RE: AI Job #19037

Project Address: 7233 80th Ave SE

Subject: Permit No. 2008-182

PLAN REVIEW COMMENTS

SHEET
A2.1

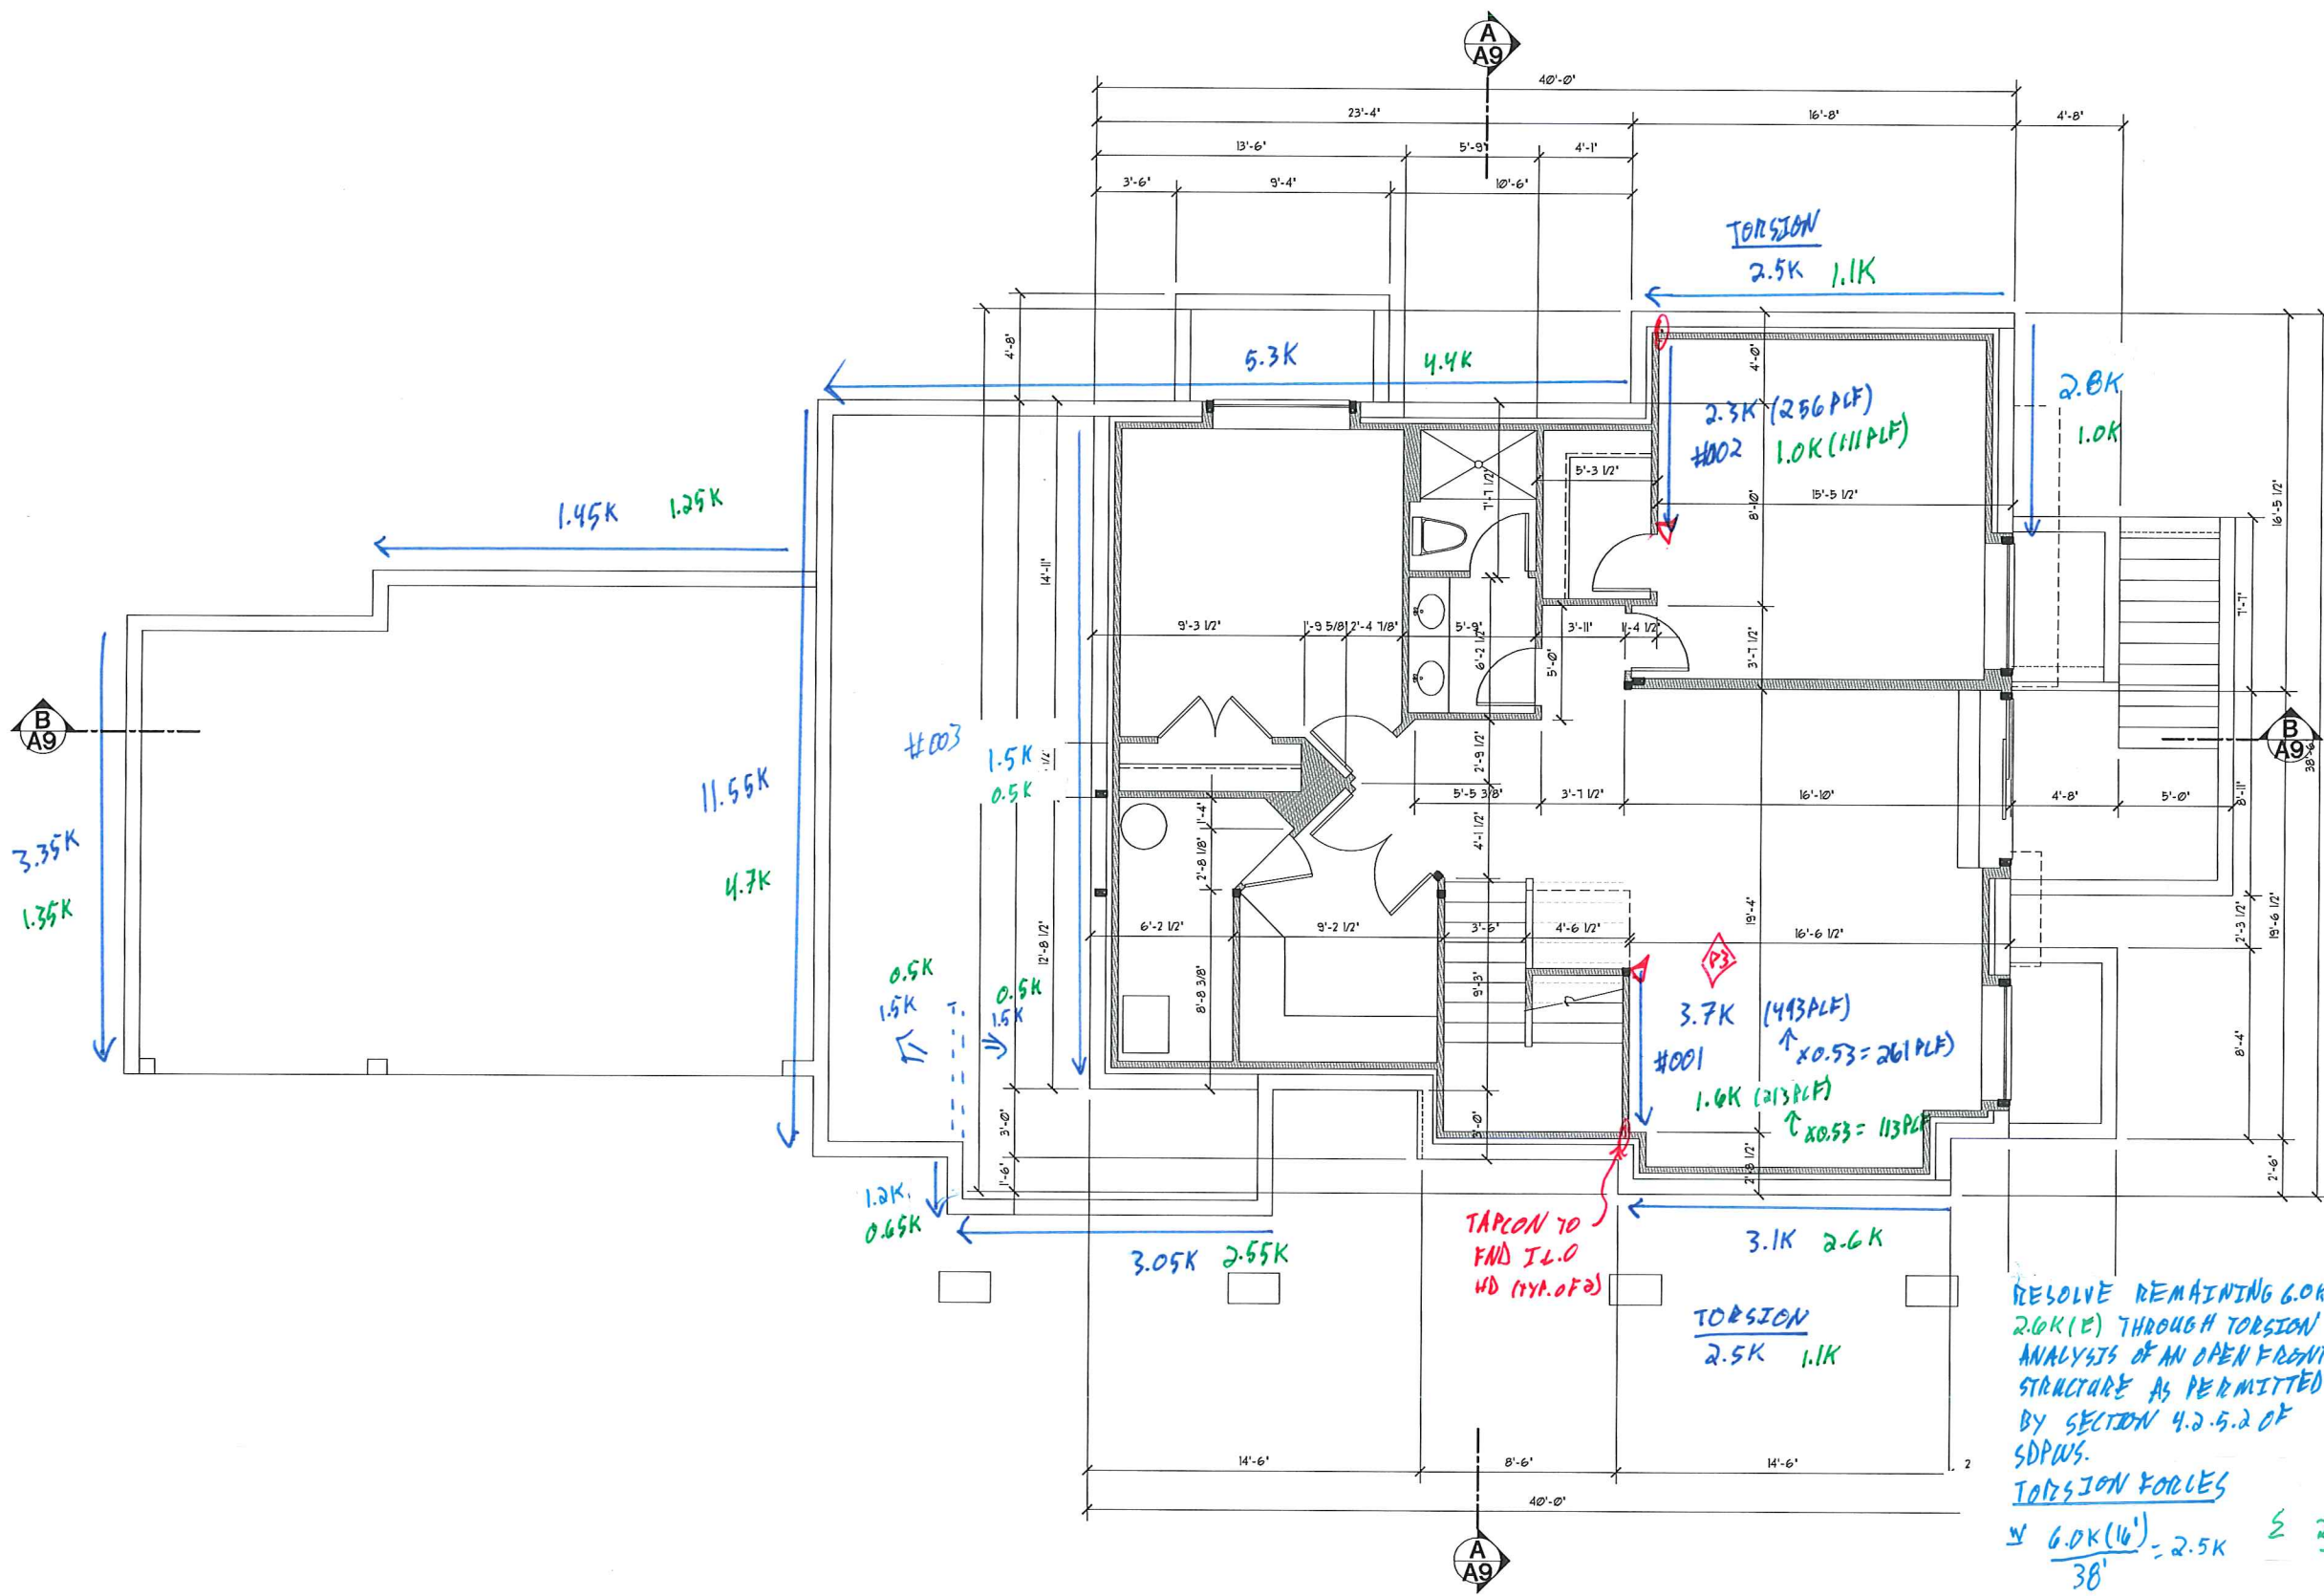
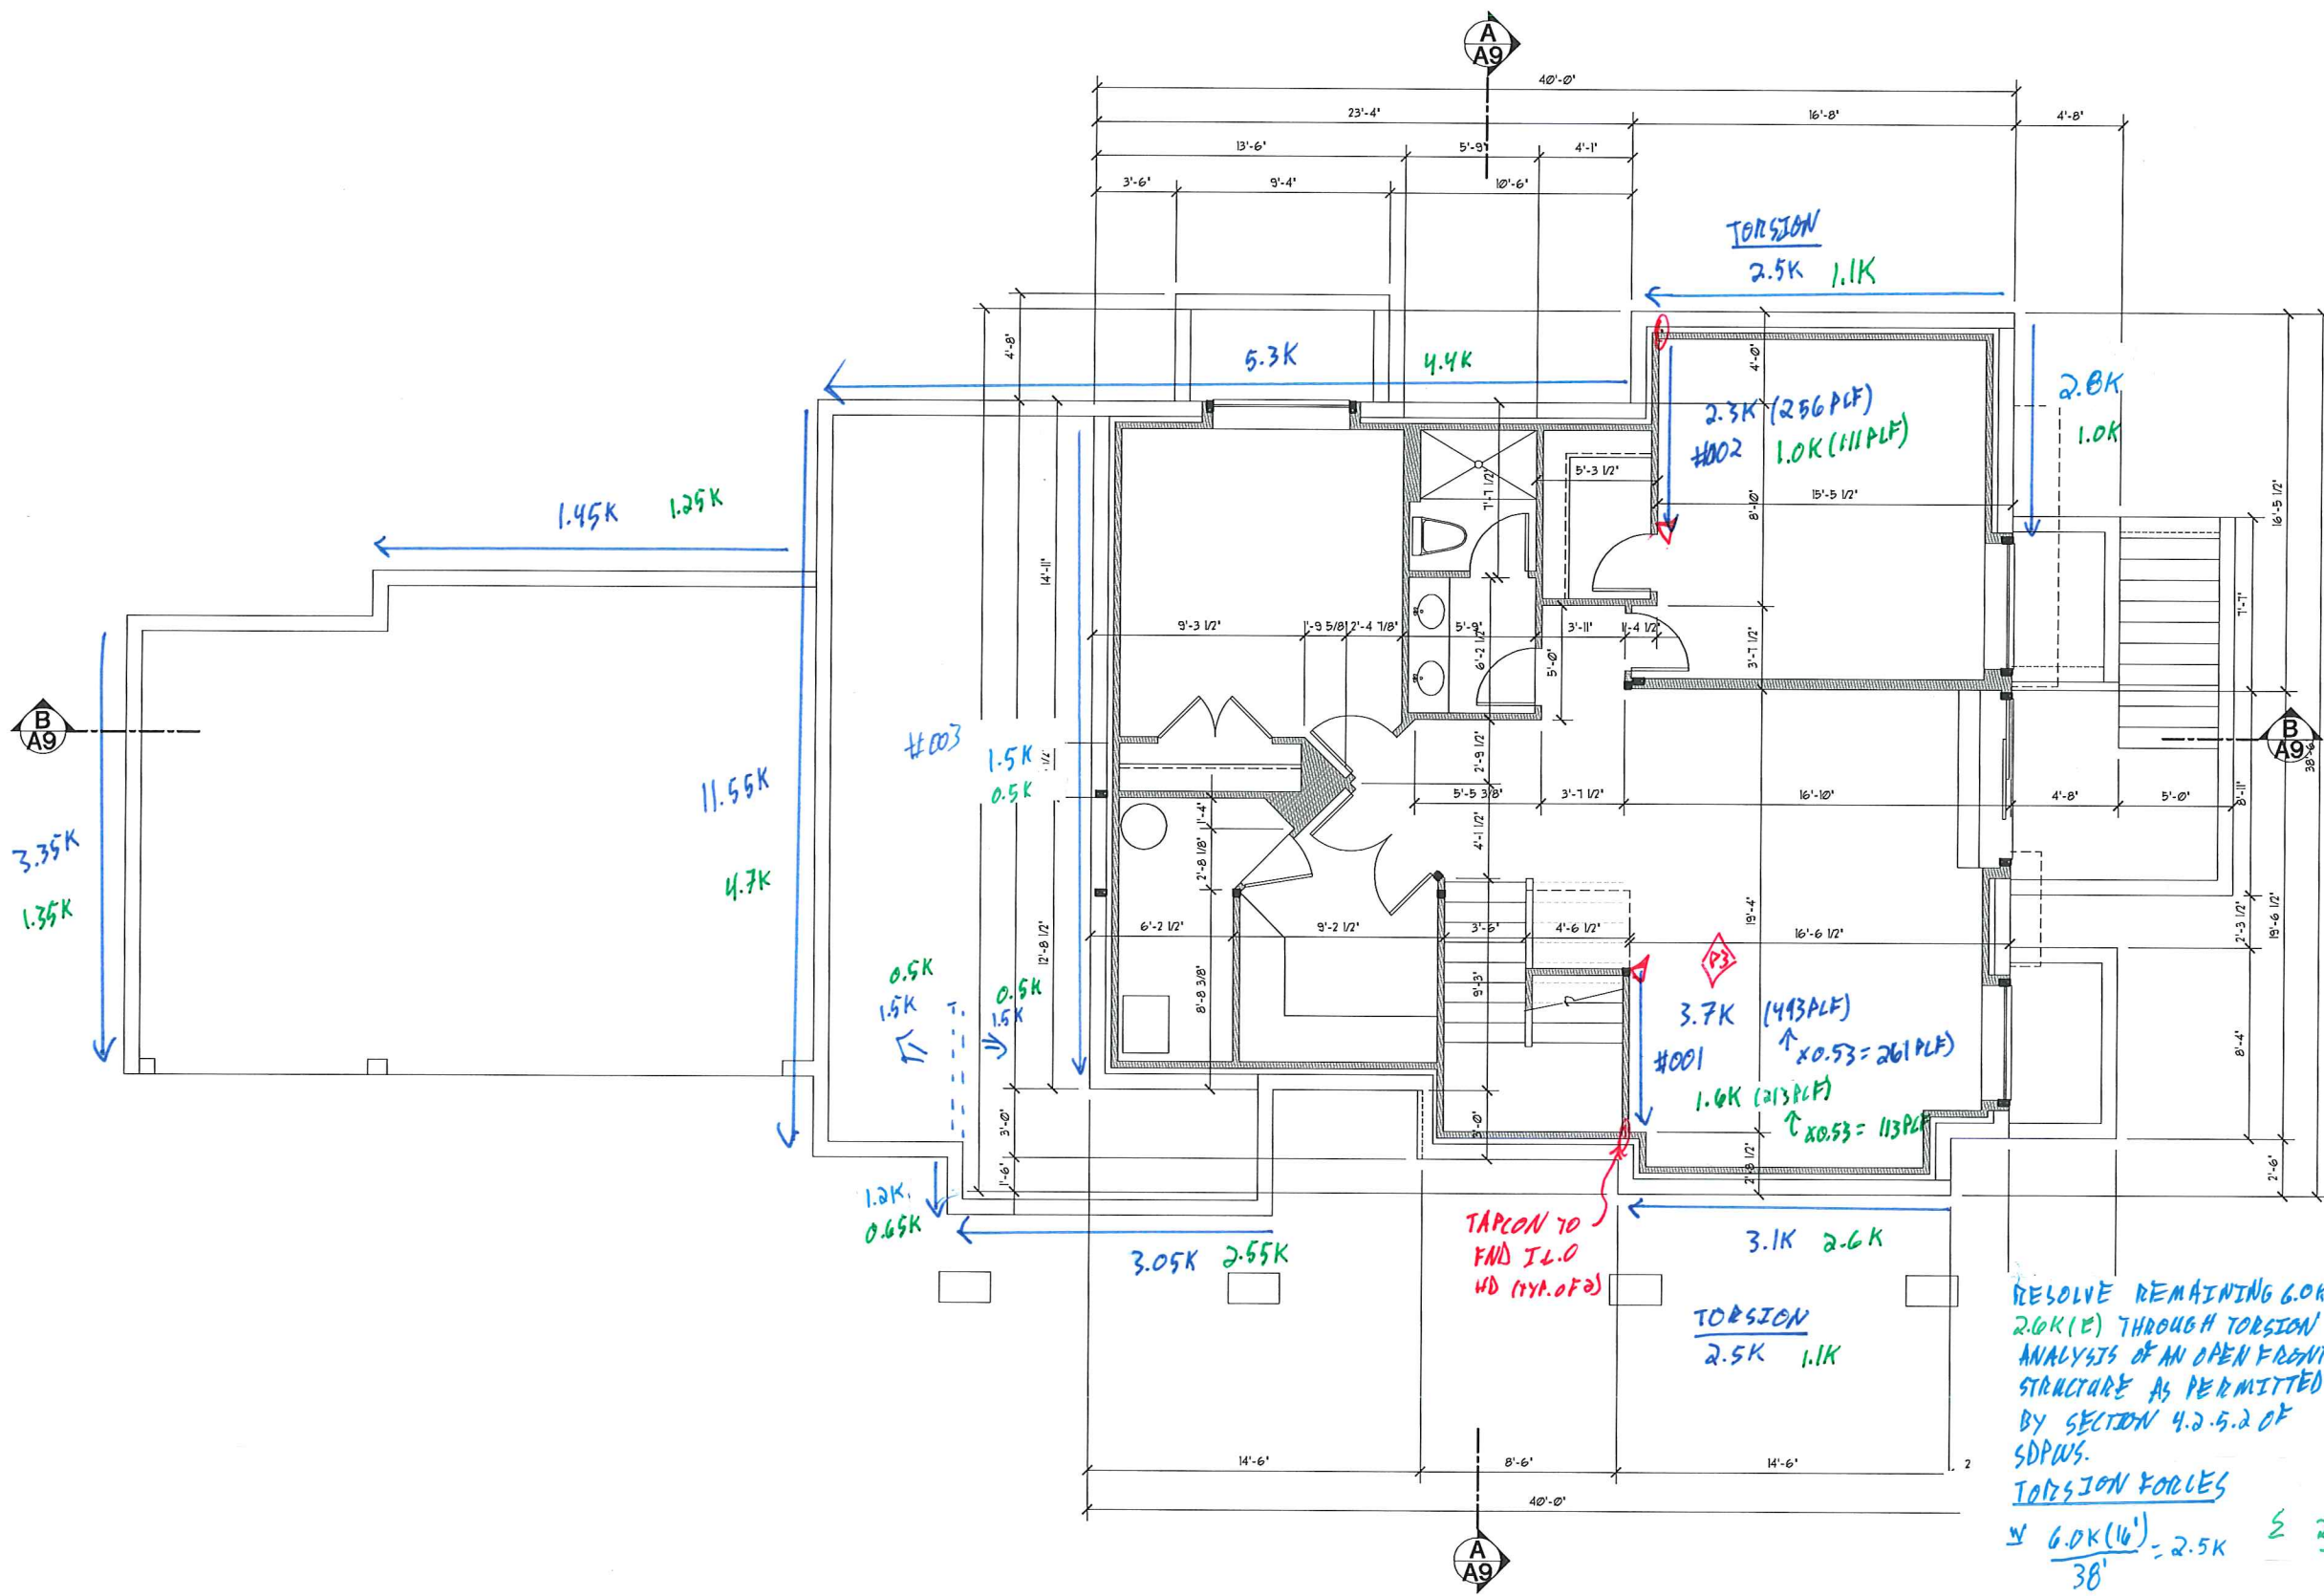
- *Comment 26: Sheet A2.1 refers to Note 19 at shear wall 001 located between the Rec. Room and stair. There is no Note 19. Please clarify.*
Response: The plans should reference note 9 for the 3" on center edge nailing shearwall. Please see the updated plans for the note correction.

- *Comment 27: Sheet A2.1 refers to Note 10 at the north end of shear wall 001 to address the connection to the perpendicular concrete wall for uplift resistance. Provide a specific detail at this connection since the sheathing at shear wall 001 will need to extend through the perpendicular furring wall to the concrete wall.*
Response: Please see the updated plans for this condition clarified, and a detail provided.
